Our ref: DOC22/423085
Sender's ref: SSI-10055

Subject: Review of exhibited Environmental Impact Statement – Inland Rail (Albury to Illabo) (SSI-10055) - Biodiversity

ATTACHMENT A – BCD Assessment Summary for Biodiversity – Environmental Impact Statement (SSI-10055)

ATTACHMENT B – Detailed comments for Biodiversity – Environmental Impact Statement (SSI-10055)

Figure 16-4 Vegetation communities of Junee precinct enhancement sites

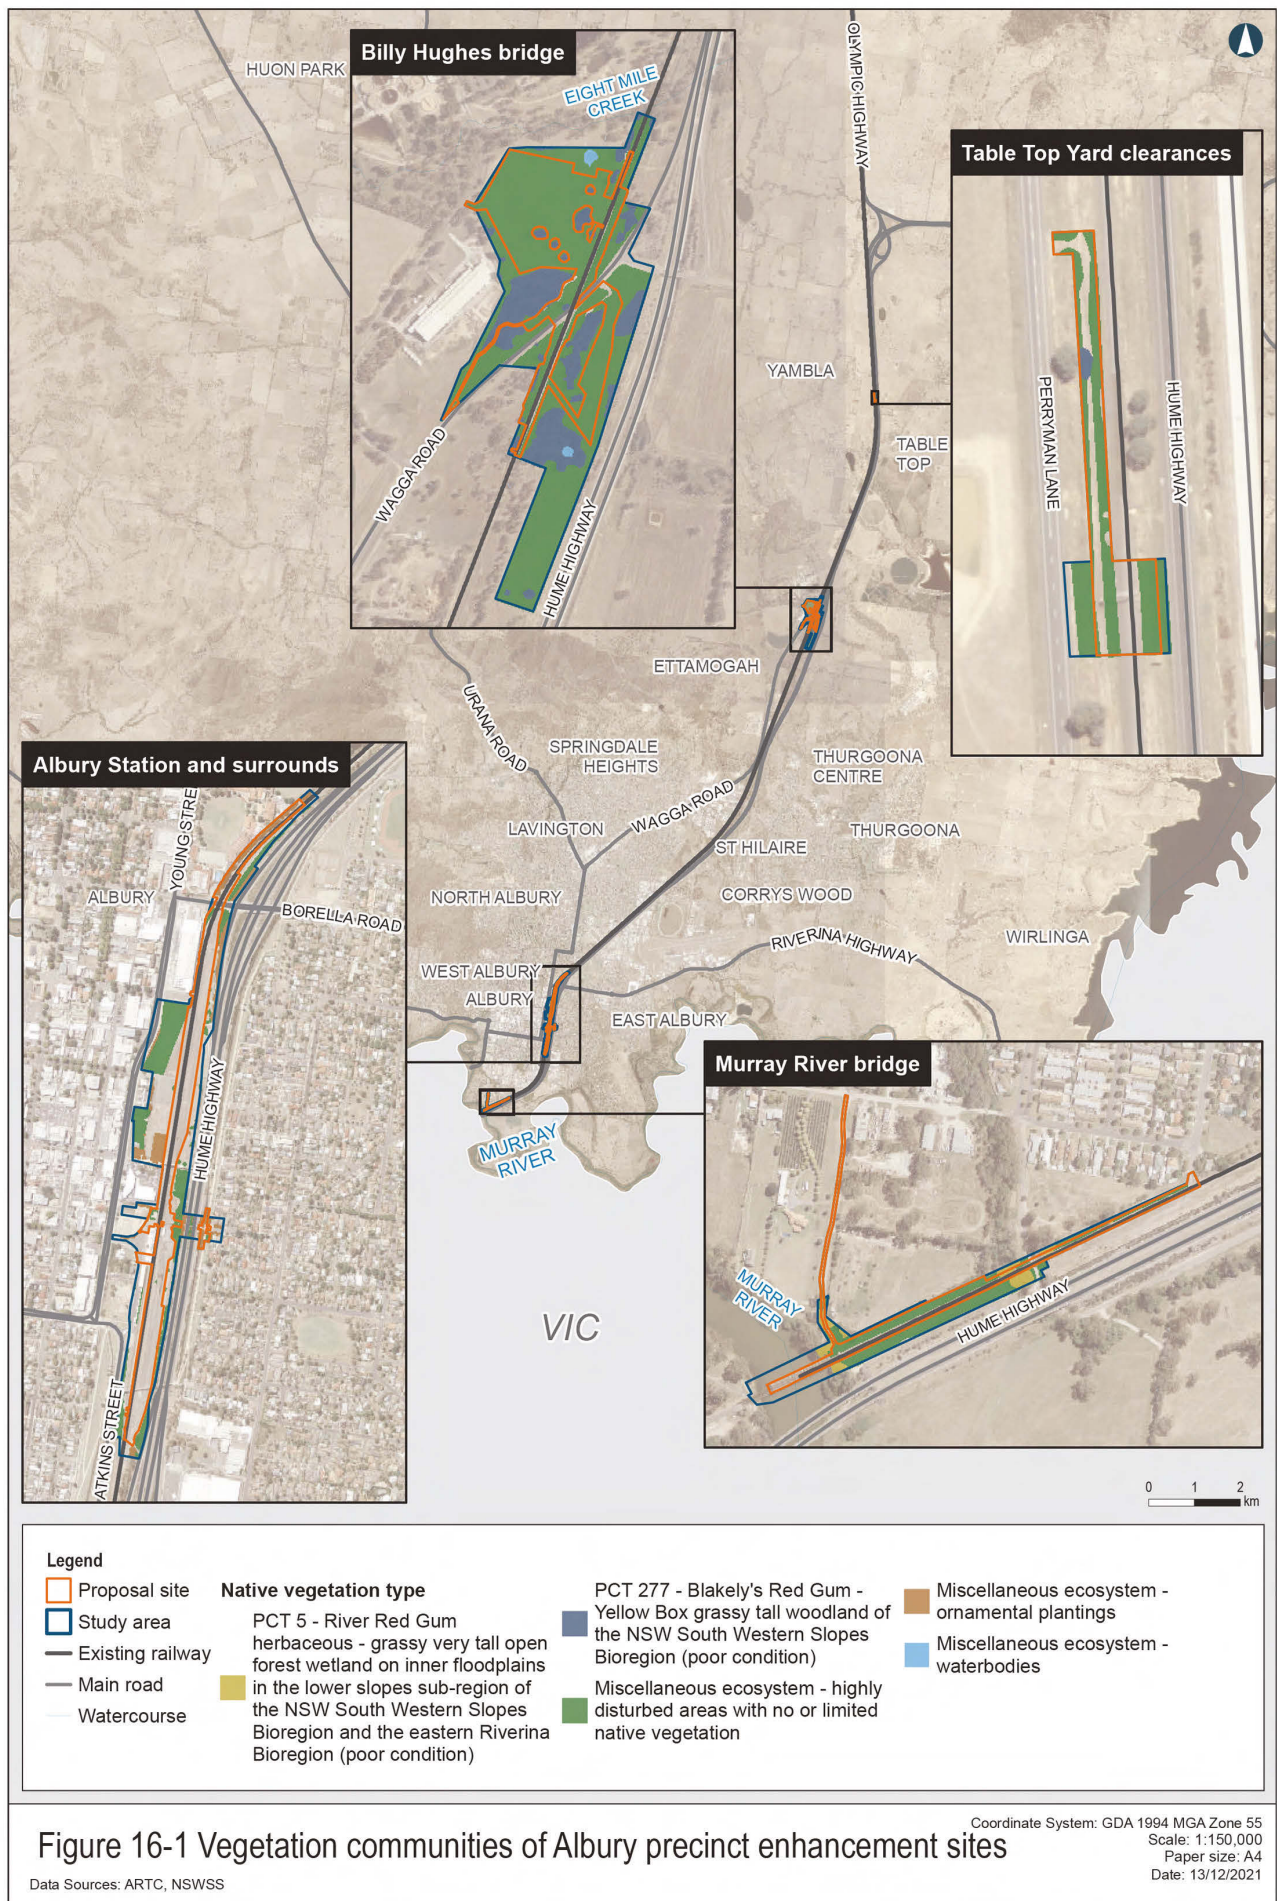
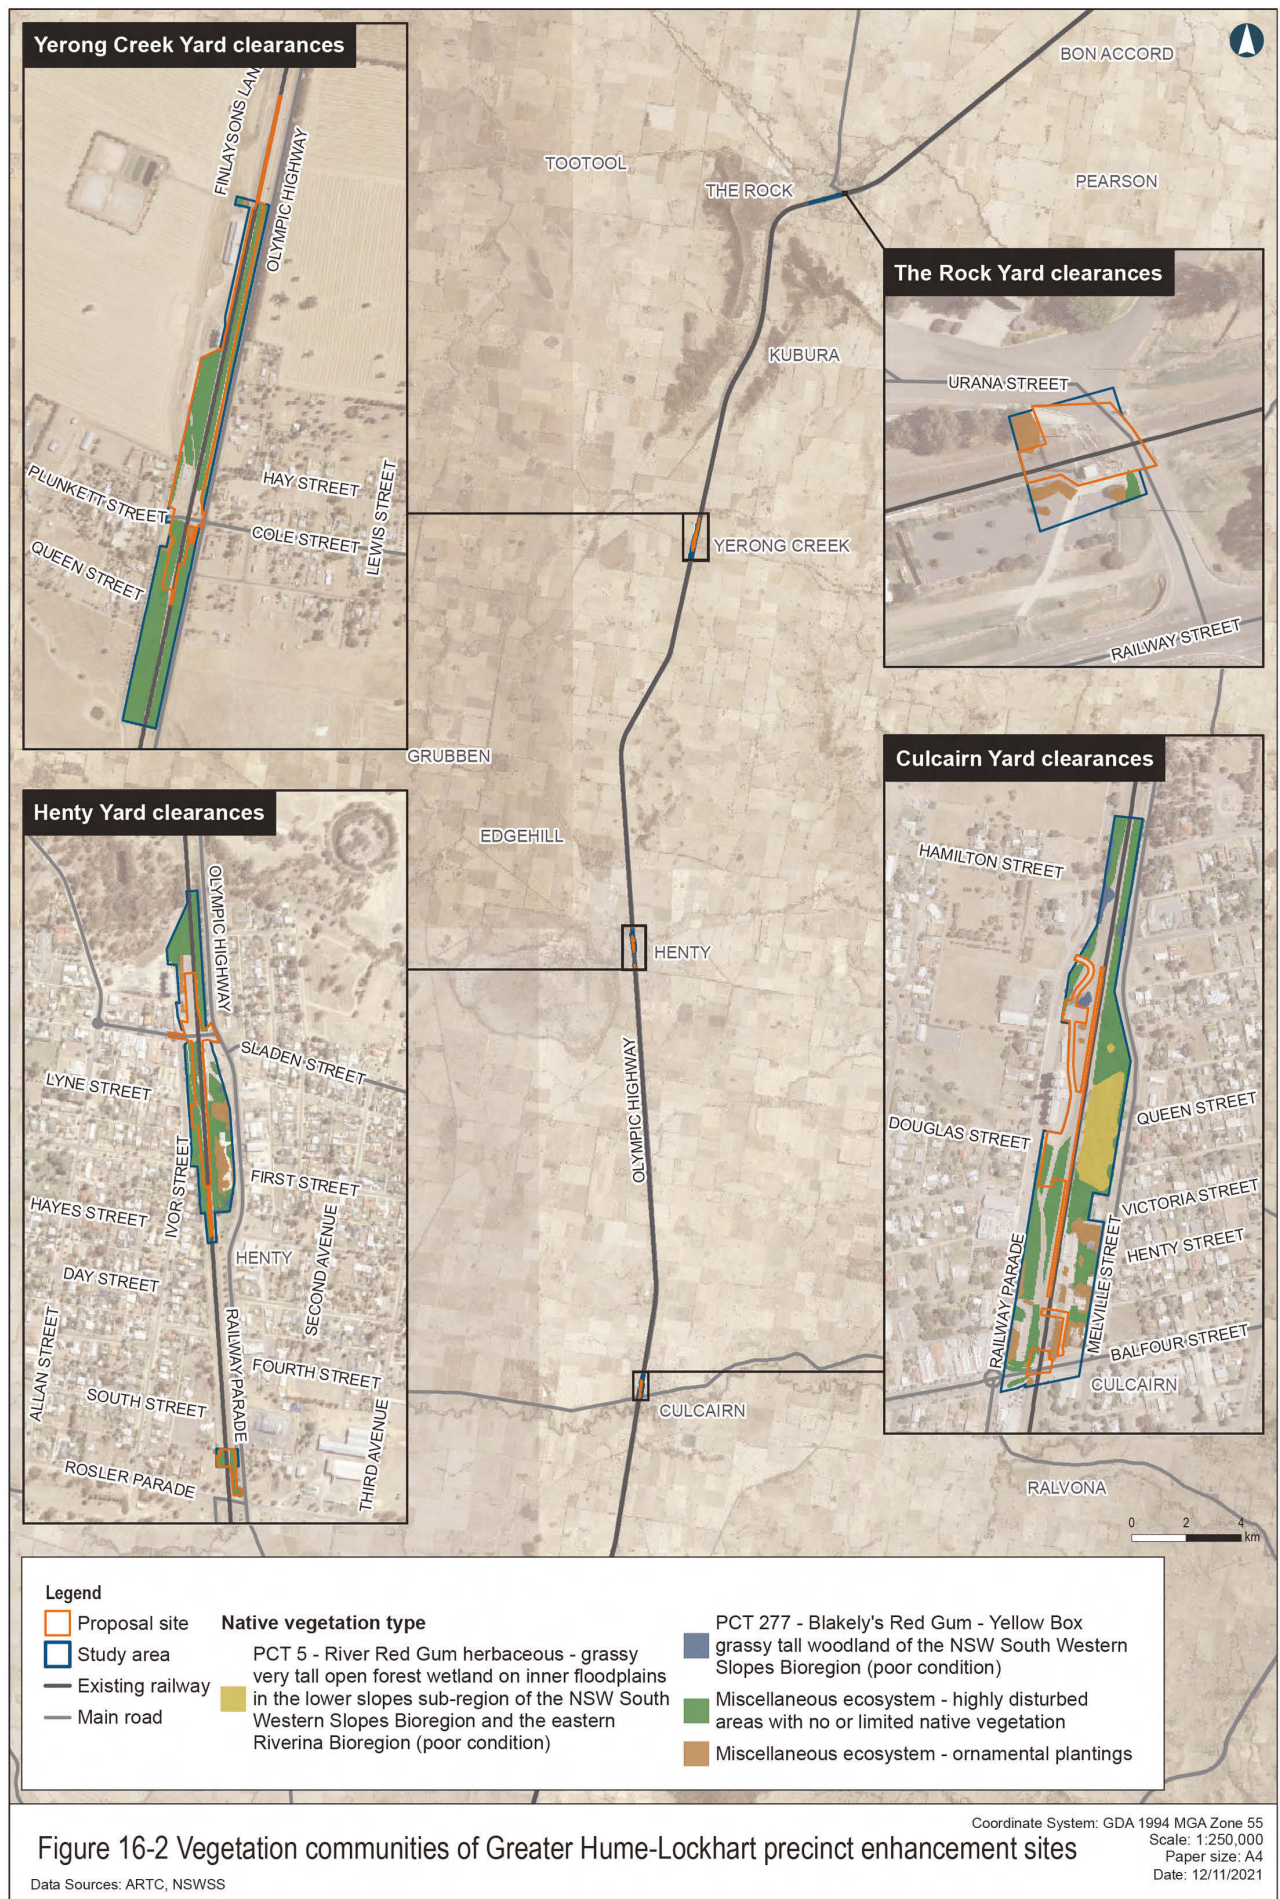
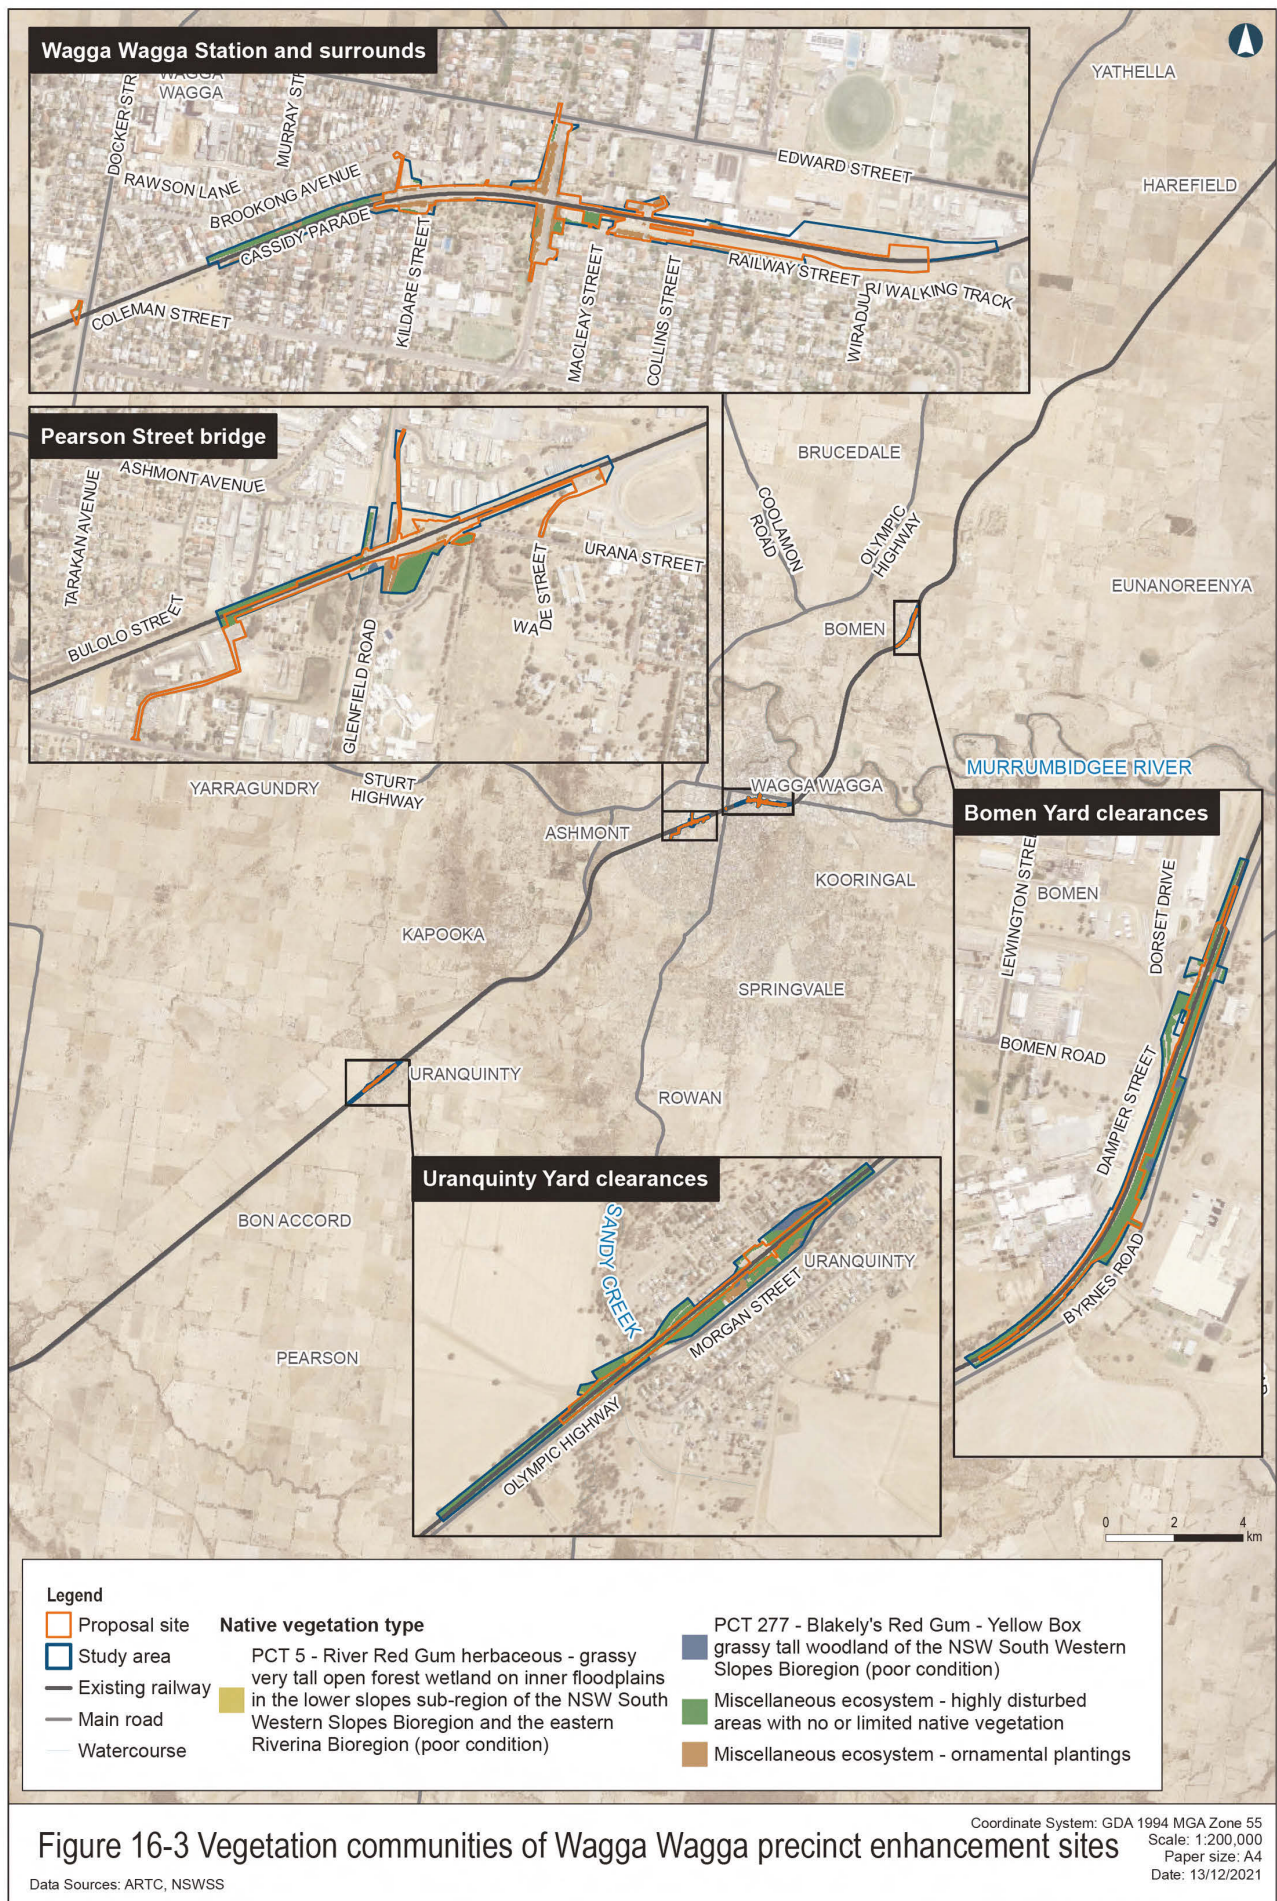
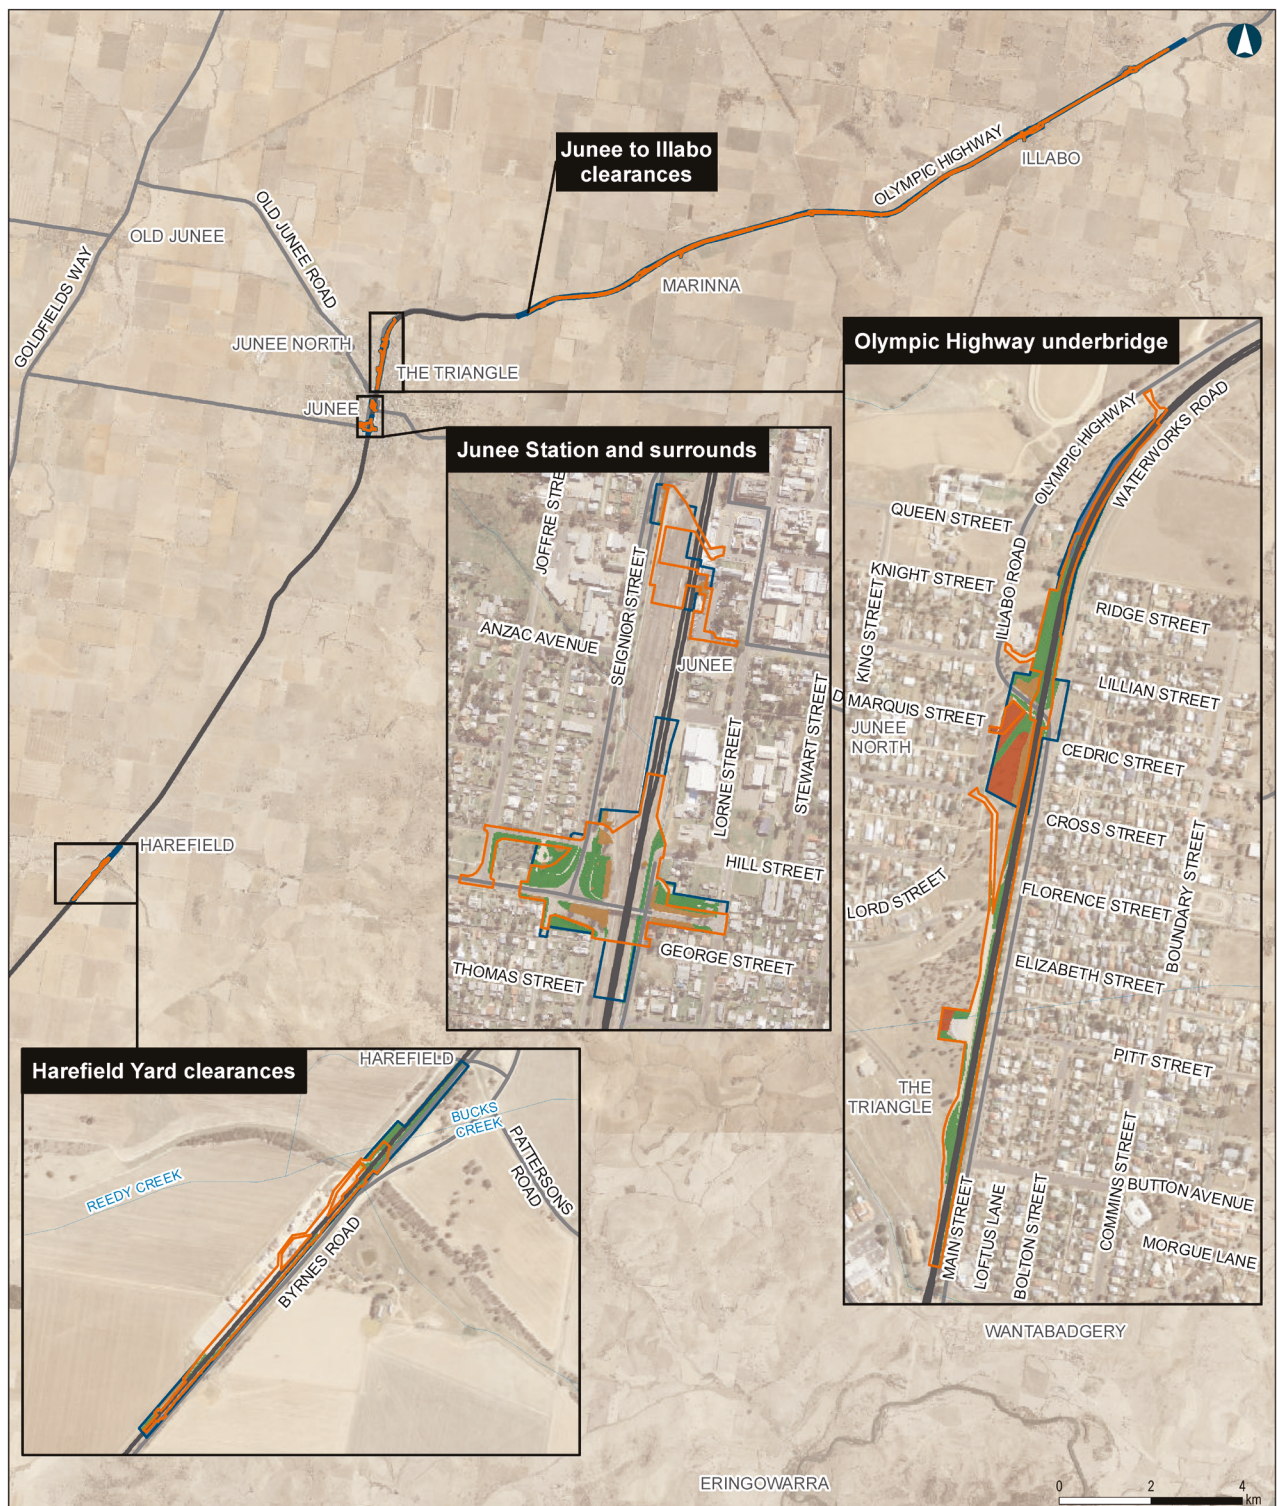
A review of the vegetation zone mapping in the BDAR and spatial data has identified a number of locations where trees that are likely to meet the definition of scattered trees have been included within discontinuous vegetation zones of PCT 277, mostly in poor condition. Noting that the scattered tree module cannot be used where threatened species are at risk of a serious and irreversible impact are present or are likely to be present, the validity of applying this module should be assessed with reference to section 9.1.1 of the BAM.

The justification for the exclusion of poor condition PCT 277 from the White Box Yellow Box Blakely's Red Gum grassy woodland and derived native grassland CEEC is not supported by existing listing guidelines or the Scientific Committee's final determination. The main justification in section 4.7.1 and Table 4.12 of the BDAR is low species richness and cover, and because:

Based on the Scientific Committee's final determination and associated advice, BCD do not support the classification of PCT 277 (poor condition) as not being consistent with the NSW Box-Gum Woodland CEEC. This vegetation zone in each subregion should be updated in the BDAR and BAM-C to be part of the Box-Gum Woodland CEEC.

- 1.1 The BDAR must clearly state that excluded land is subject to the BAM.
- 2.1 Update section 4.4 of the BDAR to include application of the streamlined assessment module - planted native vegetation.
- 2.2 For each enhancement site where 'Miscellaneous ecosystem - ornamental plantings' is mapped, the streamlined assessment module – planted native vegetation is to be applied and outcomes in accordance with the decision-making key documented in Section 4.4 of the BDAR.
- 2.3 Review vegetation zones to determine the validity of applying the scattered tree streamlined assessment module, or alternatively, provide further information to justify why allocation of scattered trees to PCT 277 (poor condition) is appropriate.
